Office of Environment & Heritage

Your Reference SSI 4951
Our reference: Doc12/47153

I refer to your letter received by the Office of Environment and Heritage (OEH) received on 9th November 2012, inviting a submission on the Environmental Impact Statement (EIS) for the Windsor Bridge Replacement project (SSI - 4951).

OEH has reviewed the EIS and has the following comments on Aboriginal cultural heritage and flooding.

Figure 7-37 | Land use and approximate extent of inundation

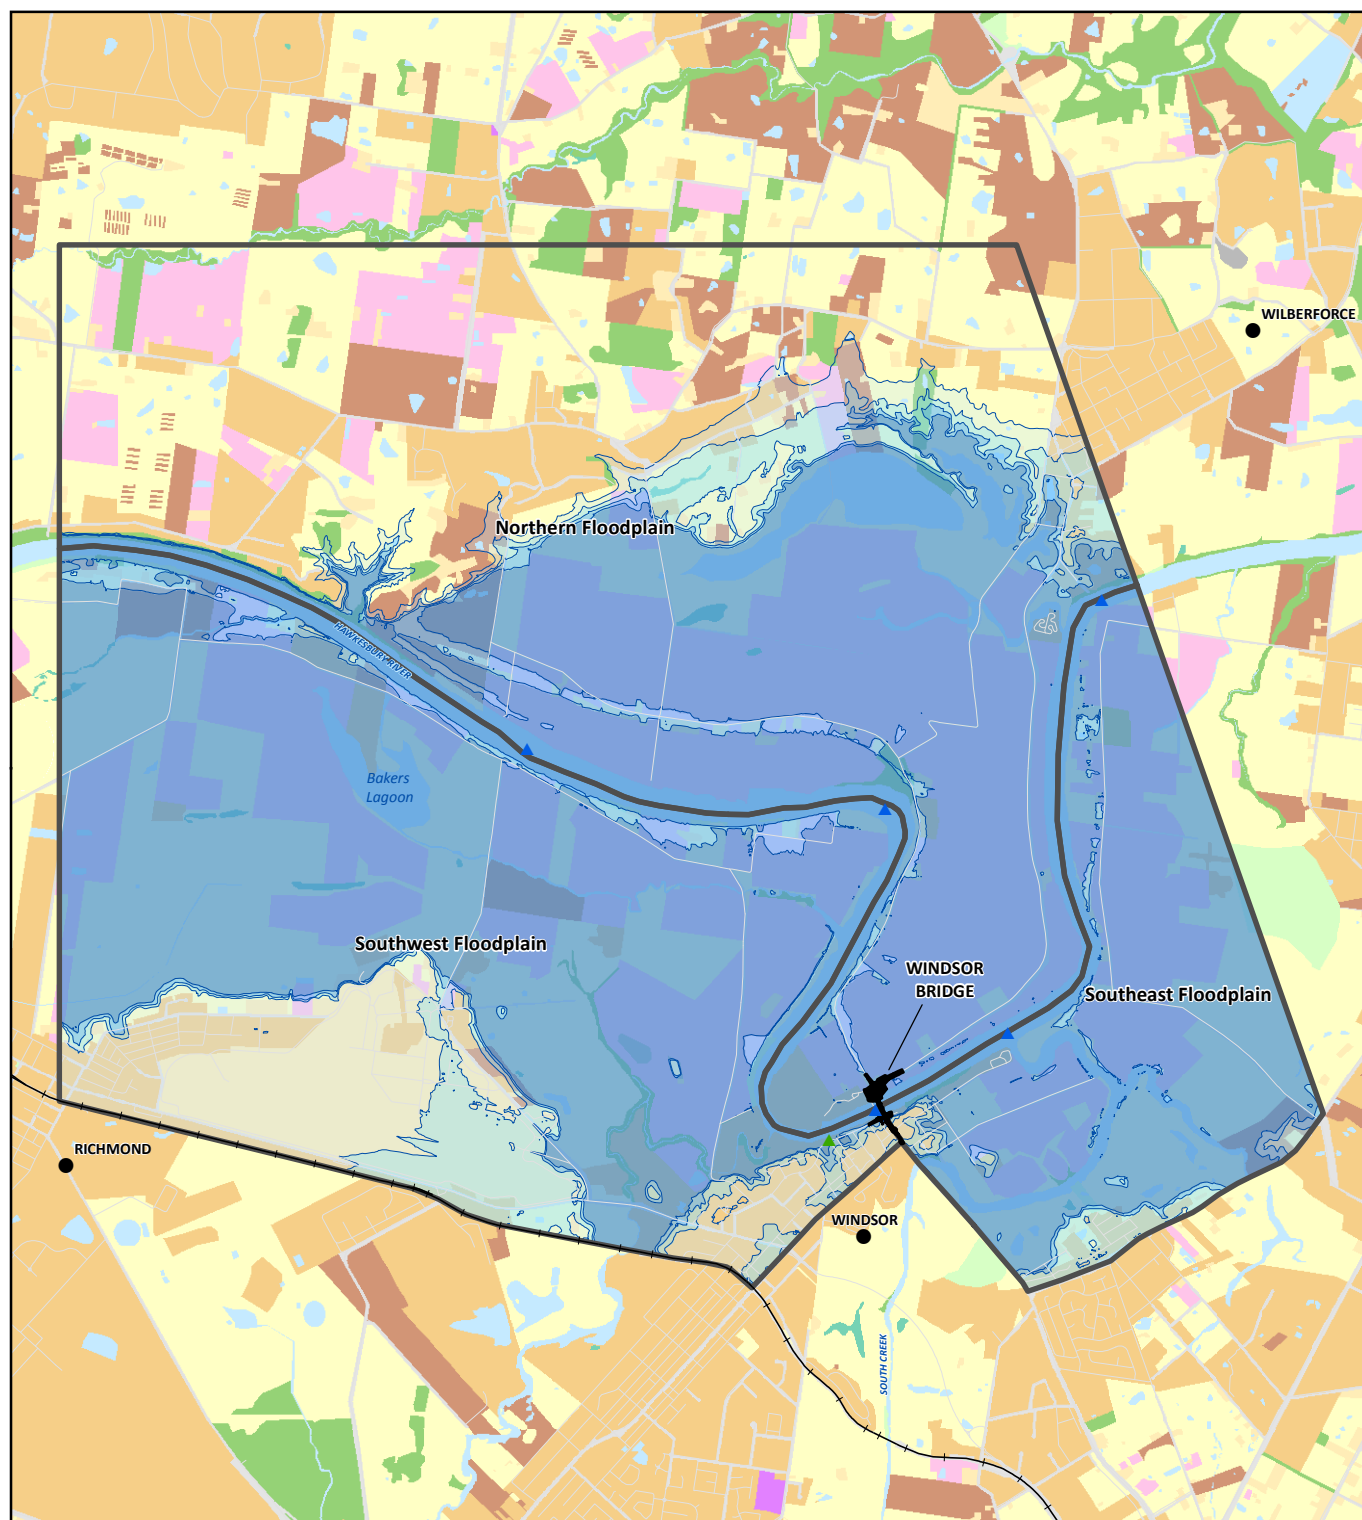
The assessment indicates the following impacts:

- 5 year ARI flood event - flood levels would increase by up to 0.12m just upstream of the project. This would affect approximately 360 lots, increasing flood levels by up to 15% in about 50 of these properties. One additional residential dwelling would experience over floor flooding due to the project, while two buildings would experience an increase in flood depth of more than 25%. These three buildings would be most at risk from the increased flood levels from the project. Flood levels would decrease downstream of the project.

- 20 year ARI flood event - flood levels would increase by up to 0.03m just upstream of the project. This would affect approximately 580 lots, increasing flood levels by less than 5%. It is estimated that four additional residential dwellings would be flooded above flood level due to the project.

- 100 year ARI flood event and greater - there would be negligible increase in flood levels as a result of the project in the 100 year ARI flood event and larger.

The potential increases in flood levels are of concern, particularly in the 5 year ARI flood event and for those additional properties affected by over floor flooding.

It is of concern that this statement pre-supposes that the increases in flood level are acceptable to those affected. It is therefore recommended that this issue be discussed with Hawkesbury City Council in the first instance so that a community engagement strategy is developed prior to any determination of this project. One suggestion for Council would be to individually write to all affected property owners and occupiers.

It is also recommended that the State Emergency Service (SES) be consulted at the same time on how increased flood levels from the project could impact on its emergency management procedures, particularly the evacuation of properties.
